Submission No.			252	
Organisation Name or Name of Submitter			Paul Cusack (on behalf of residents of 153 Ballymun Road)	
Item No.	Section Ref.	Page No.	Observation Statement	TII Response
Letter Re: Collins Avenue Metro Station				
1	Summary	1	We submit based on considerations of service provision, community and environmental impact, both in the operational and construction phases, that relocation of the proposed DCU stop (also known as Collins Avenue Station as illustrated in diagram no. 14 below) to a location of ultimately small visible footprint along the western periphery of Albert College Park is a more suitable option. This community strongly believes this would be a superior solution to the current design proposal to locate the station on the forecourt of our Lady of Victories Church on Ballymun Road.	<p>As outlined in EIAR Chapter 7, Consideration of Alternatives, section 7.7.10.7, the assessment undertaken for the Emerging Preferred Route (EPR) identified a preferred route option including the proposed station location in front of Our Lady of Victories (OLV) Church.</p> <p>This location for the station provides a number of advantages when compared to other location option

COLLINS AVENUE STATION

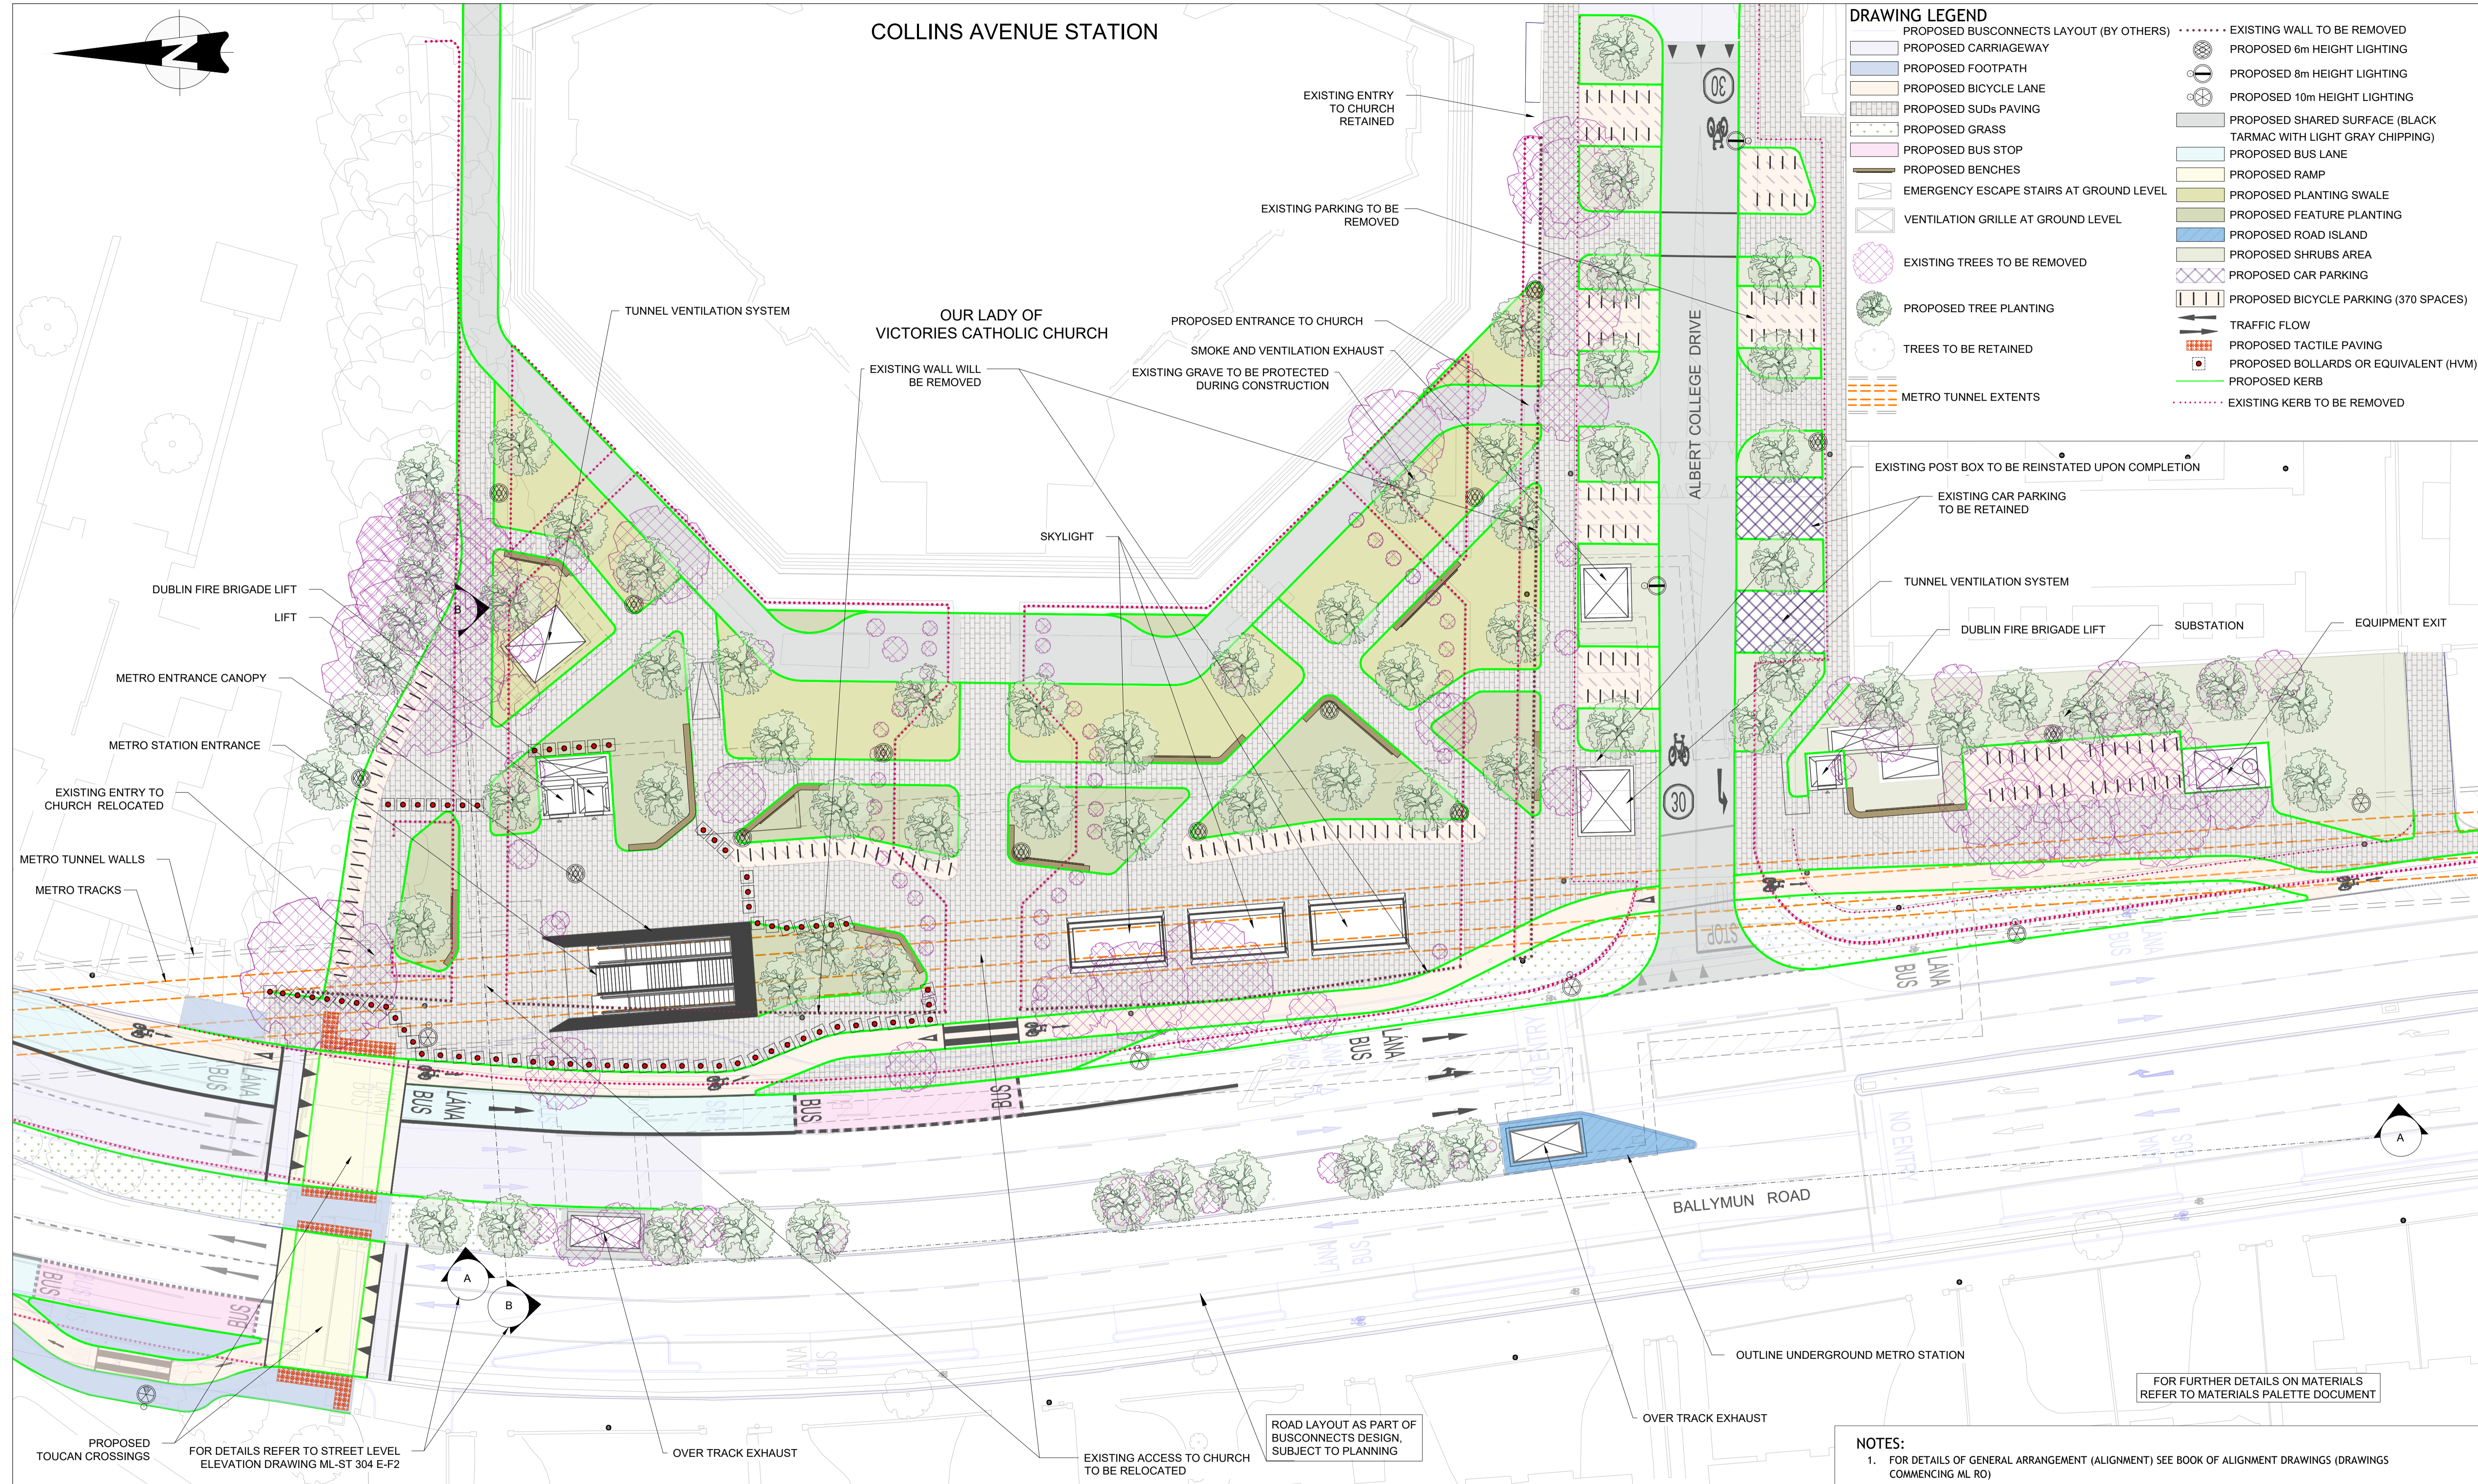
Submission No.			252	
Organisation Name or Name of Submitter			Paul Cusack (on behalf of residents of 153 Ballymun Road)	
Item No.	Section Ref.	Page No.	Observation Statement	TII Response
Letter Re: Collins Avenue Metro Station				
6	Senior Citizens In Albert College Court Assisted Living Accommodation	4	Our concerns are threefold: 1. The major scale and the resultant noise and vibration caused by the excavation equipment that will be deployed to insert the station diaphragm walls which are in such close proximity to these houses.	The EIAR Appendix 13.2 Airborne Noise Construction Phase Modelling presents predicted airborne noise levels, both before and following mitigation, to construct Collins Avenue Station. Receptor 39 represents Albert College Court. Predicted construction noise levels are below the construction noise threshold level of 75 dB at this location during all working phases, indicating no significant adverse impacts. As outlined in EIAR Chapter 14, section 14.4.1, groundborne noise and vibration at this location for the station construction will be below the threshold of significance for construction.

7	Senior Citizens In Albert College Court Assisted Living Accommodation	4	2. The extreme proximity of the periphery of the construction site compound located at the main entrance of Albert Court on the church side of the complex. The current compliment of allocated street parking spaces for these residents will be subsumed into the construction site further increasing access issues for these residents.	Please refer to response item (3) in relation to the loss of parking at Albert College Court. Please note that it is pay and display parking spaces (not resident parking spaces) that are impacted, as indicated in Appendix A9.5 Scheme Traffic Management Plan section 7.4.6.3.5.

Response (8) continued.	<p>The CNVMP(Construction Noise and Vibration Management Plan) will set out a detailed analysis of each construction compound relating to noise levels, durations and number of properties impacted and the planned approach for managing same, as indicated in EIAR Appendix A5.1 Outline CEMP. It is reiterated again that prior to any construction work commencing on any of the main work sites a detailed acoustic impact assessment will be undertaken which will involve a baseline noise study, model of the contractors final site layout, plant and equipment models, numbers and on-site location and the inclusion of all available on-site noise control measures. This is detailed in section 6.2 of EIAR Appendix A5.1 Outline CEMP. There are no statutory standards in Ireland relating to noise and vibration limit values for construction works. The contractor(s) will work within the noise and vibration significance threshold levels identified in the EIAR for both airborne and groundborne noise and vibration and the limits contained in the Railway Order approval. This is considered to be an approach in line with best practice.</p> <p>Lack of consultation TII disagree that meaningful communication has not taken place. TII have undertaken stakeholder and public consultation throughout the Project development. Consultation has included, but was not limited to, the Emerging Preferred Route consultation, Environmental Impact Assessment Scoping Consultation, Preferred Route Public Consultation and the Albert College Park Local Area Consultation. As detailed in Appendix A8.19 Meetings Register, five meetings were held with Albert College Residents Association, with eight meetings held with Ballymun Road Area Association (residents association), and one meeting with the Collins Avenue Residents Association.</p>
